From: Iain Osenton <iain.osenton@cherwell-dc.gov.uk>
Sent: 31 May 2022 15:39
To: Planning <Planning@Cherwell-DC.gov.uk>; dcregistration <dcregistration@Cherwell-DC.gov.uk>
Cc: David Lowin <David.Lowin@Cherwell-DC.gov.uk>
Subject: 22/01144/F - CDC Arboriculture

Please see below from desk based assessment my initial observations.
Comment – More information required.

Registered office: 01285 740427 - www.edp-uk.co.uk - info@edp-uk.co.uk

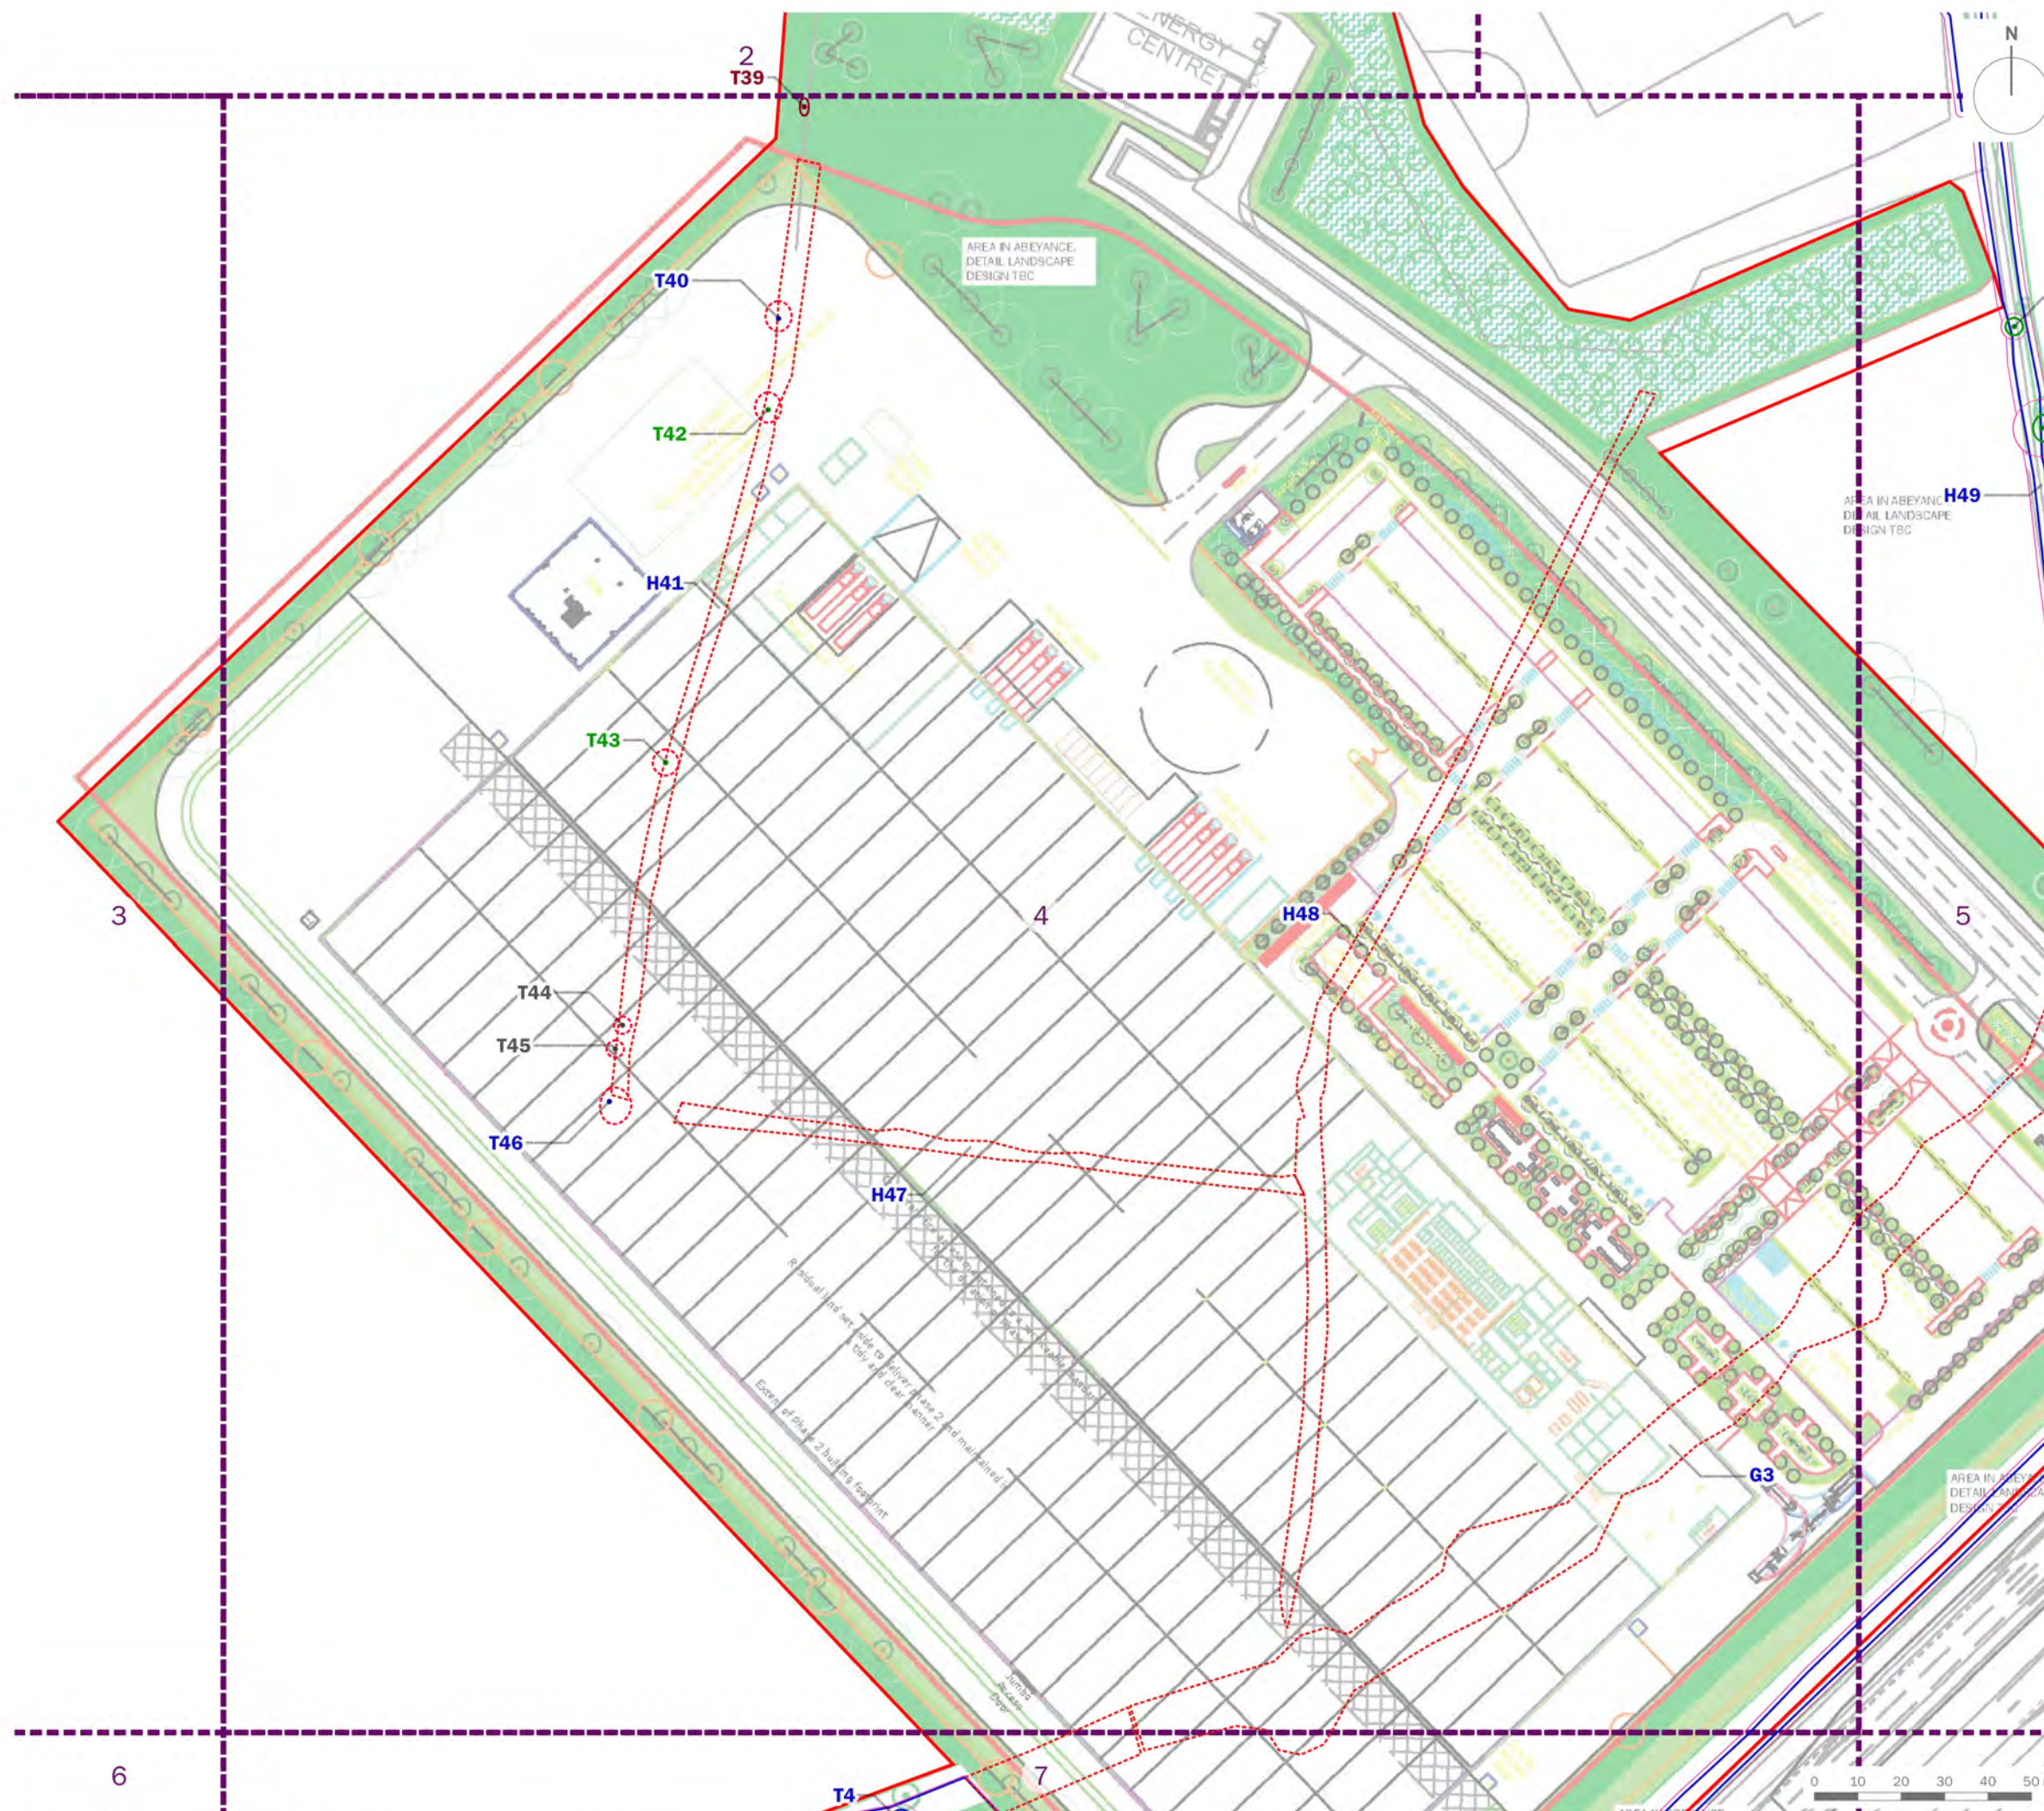
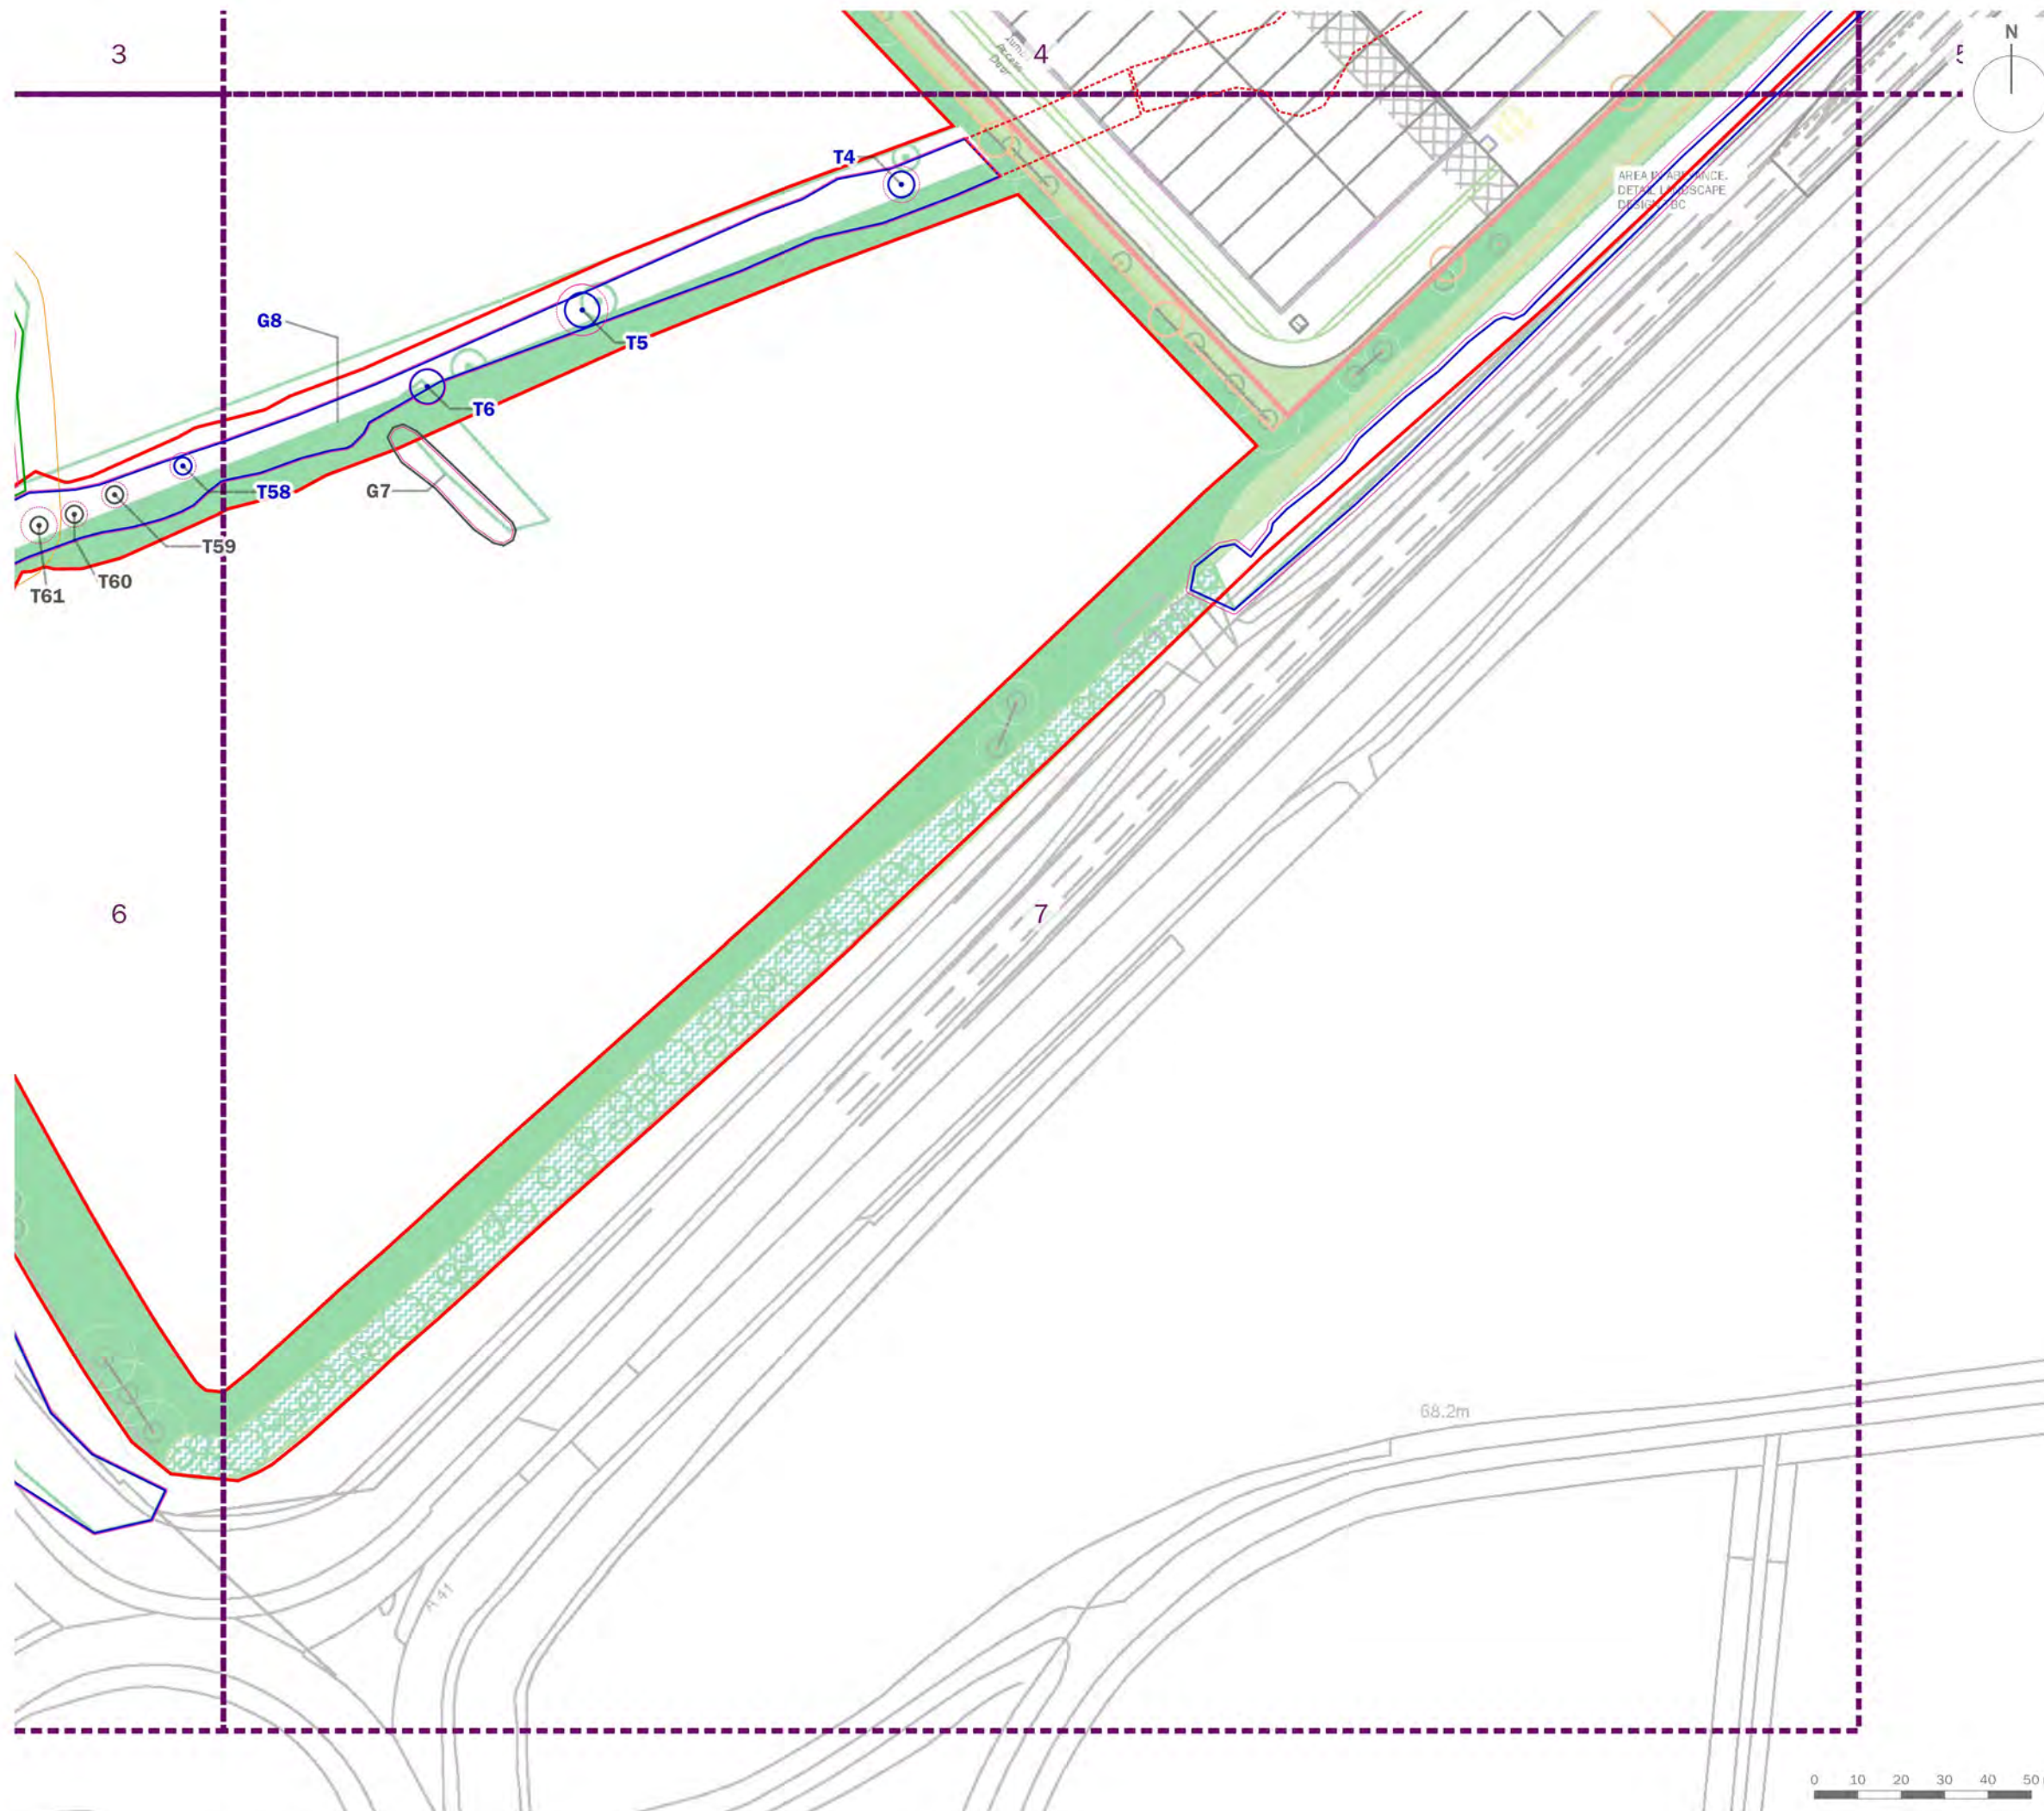
- Confirm justification for T37 removal.
- Confirm if hedgerows proposed for removal are protected under hedgerow regulations (if this is covered in ecological assessment please state).
- Method for operations upon ancient woodland border/buffer area. (See below comments for method statement).

An AMS is included within the report however, some further details will be required. It is acknowledged some of this information is likely unavailable currently. 3.14 states service locations, whilst remaining outside RPAs are subject to confirmation from the applicant. The AMS does not include a plan demonstrating tree protection fencing, though it is acknowledged the majority of vegetation sits outside the area of development. The AMS does not include a methodology for working within the ancient woodland buffer for redirecting drainage, and does not include details such as the site compounds location mentioned in 3.20.

- Methodology for working within the ancient woodland buffer.
- Confirmation of service locations.
- Confirmation of site compound location.
- Full AMS/TPP plan including access.
